CITY OF PORTLAND, MAINE

PLANNING BOARD

March 24th, 2016

Project Name: **Construction of new four-unit residential condominium building**
Level III Subdivision and Site Plan
Project #: #2016-005
Address: 31 Fore Street, Portland
CBL: 016 J026001
Applicant: Peninsula Property Development
Planner: Jean Fraser

**PARKING SPACE DIMENSIONS**  
NOT TO SCALE

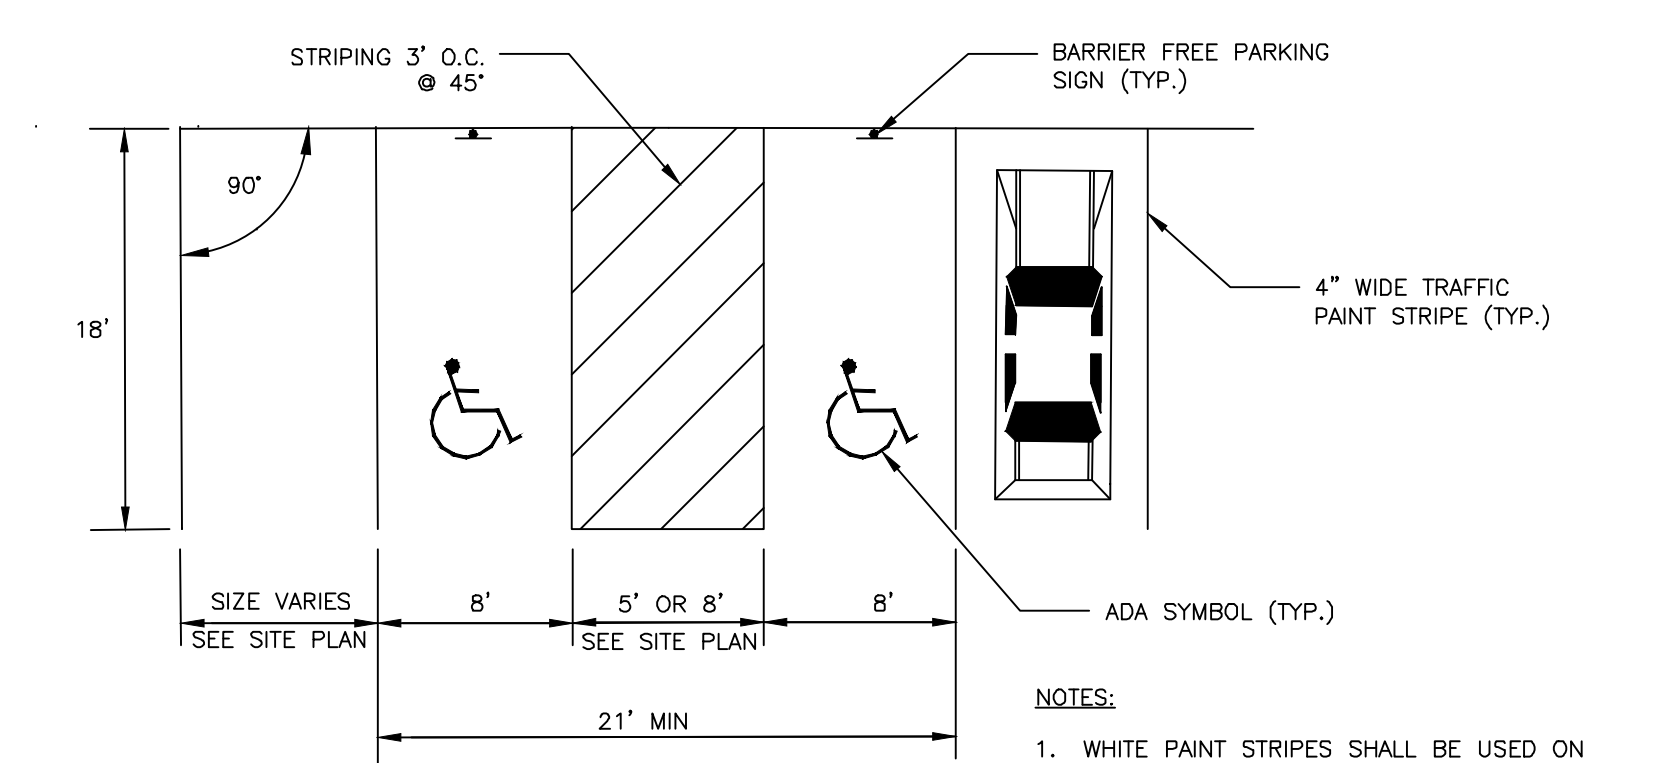
- vii. That the applicant shall submit a revised parking layout within the parking garage to show an ADA compliant parking space, for review and approval by the Planning Authority prior to the issuance of a building permit. The applicant may convert up to 2 spaces to be less than standard size and may reduce the number of parking spaces to meet this requirement, subject to meeting zoning requirements and satisfying the Traffic Engineer regarding operation.

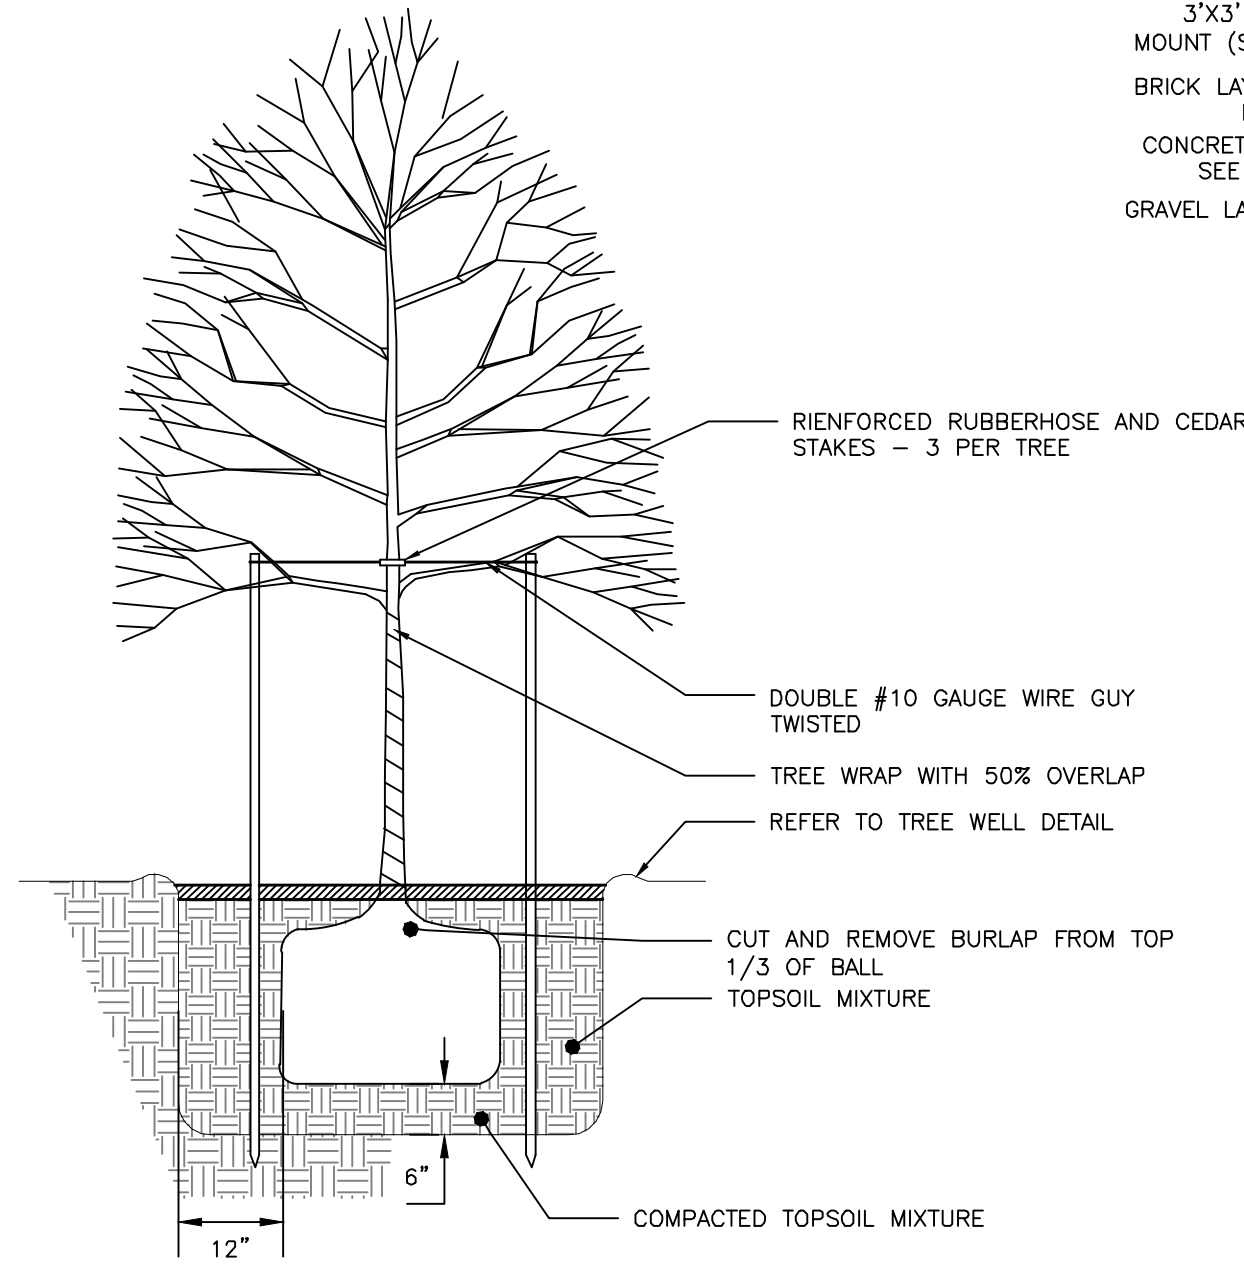
- iv. That the applicant shall take all measures to protect the existing street tree on Fore Street as recommended in the City Arborist comments dated 3.16.2016; and

BICYCLE HITCH DETAIL
NOT TO SCALE

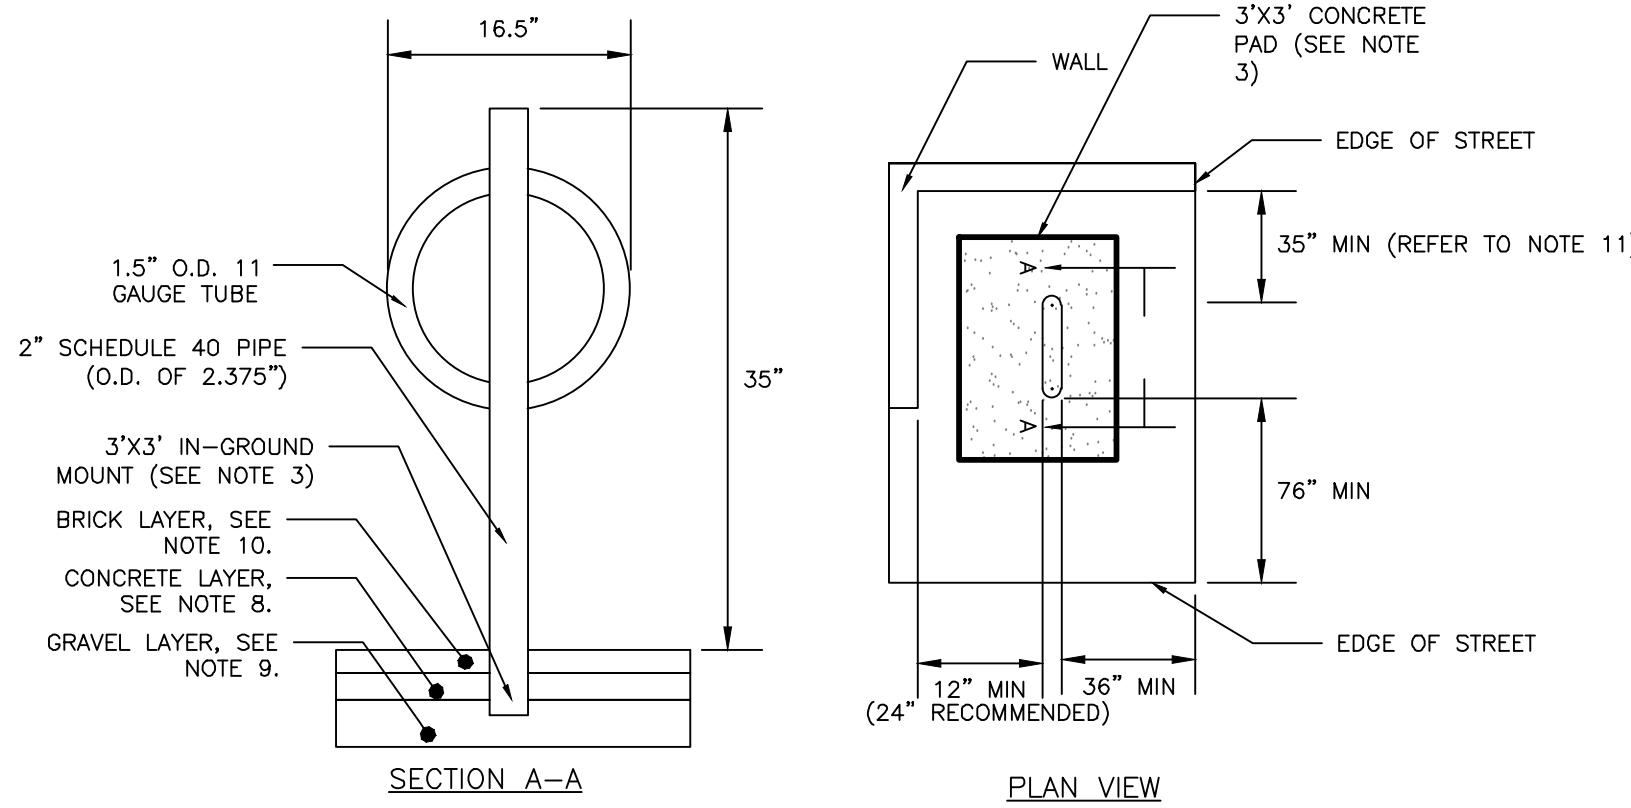
- b. Ensure that the bicycle parking hitches in the ROW are designed to meet the Technical Standards; and
 - c. Show that the design of the balconies will direct drainage and ice/snow so that it will not fall on the sidewalk.
